## Appeal Decision

### **Appeal Ref: APP/R4408/W/19/3221848 79 Huddersfield Road, Barnsley S75 1AA**

- The appeal is made under section 78 of the Town and Country Planning Act 1990 against a refusal to grant planning permission.
  - The appeal is made by Mrs C Lin against the decision of Barnsley Metropolitan Borough Council.
  - The application Ref 2018/1209, dated 30 July 2019, was refused by notice dated 23 November 2018.
  - The development proposed is an extension at rear and upper floors to form one self-contained maisonette above existing Class A5 retail premises.
-

FRONT ELEVATION as proposed

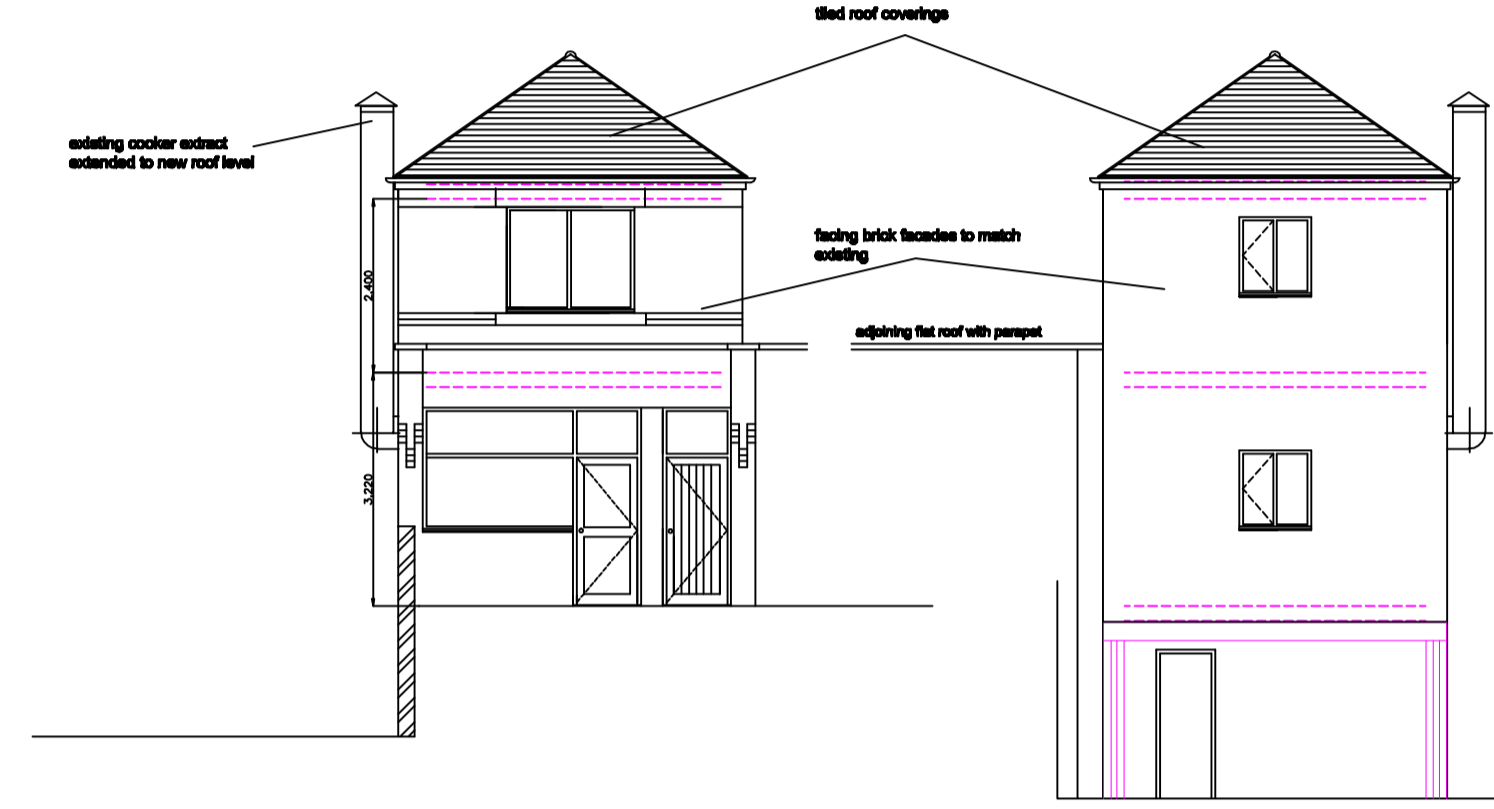
8. The Council's decision notice refers to policy CSP29 of the Core Strategy 2011 which has been replaced by the Barnsley Local Plan 2019 (LP). Policy D1 refers to the need for high quality design to contribute to local character. This is a revised scheme and the design has been altered to ensure that the development would have a satisfactory appearance. The replacement of the flat roof of the commercial unit with a first floor with a hipped roof would be a positive feature of the proposal that would gain support from this policy.

FIRST FLOOR PLAN as proposed

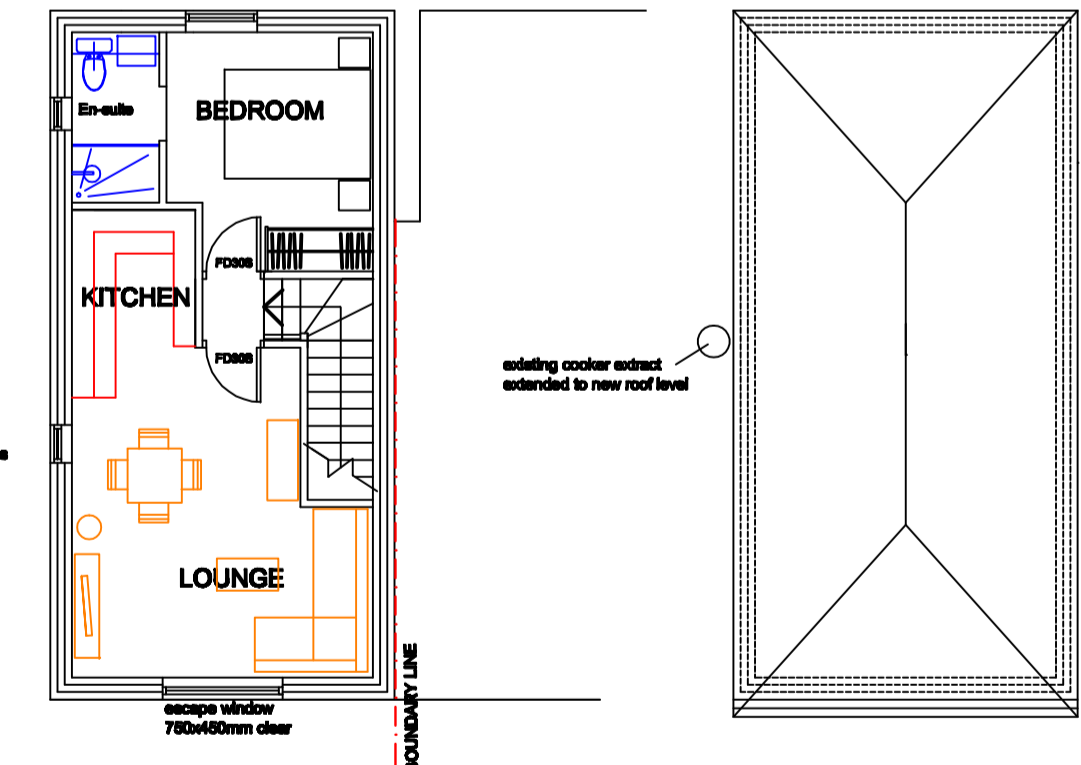
5. The plans show an open plan lounge/kitchen to the front of the property. This would include a living area with a corner sofa illustrated. The room would have a window that would face the road and the open parkland opposite. A small kitchen and a separate dining table are shown at the other end of this room. A bedroom would be located to the rear. The plans illustrate a small double bed with bedside tables and a built in wardrobe. A small en-suite bathroom would provide a shower and toilet.

6. The flat would be small but the furniture layout suggests that residents would have adequate living space, albeit with very limited circulation space in the bedroom and minimal storage provision. The bathroom would also be small but would be entirely serviceable for a small household. The kitchen would be compact but with full height units with integrated appliances and a dual washing/drying machine, it could offer all necessary facilities. I am satisfied therefore that it could provide all the requirements of an independent unit of accommodation. It would be more suited to single occupancy but could accommodate a couple given the space within the bedroom and lounge.

or external standards. However, the limited manoeuvring space within the flat and the narrow stairs to the first floor would not allow for a full range of users as wheelchair accessibility within the accommodation could not be achieved. I find general support from the policy but I acknowledge that in this respect, there would be some conflict with its requirements.
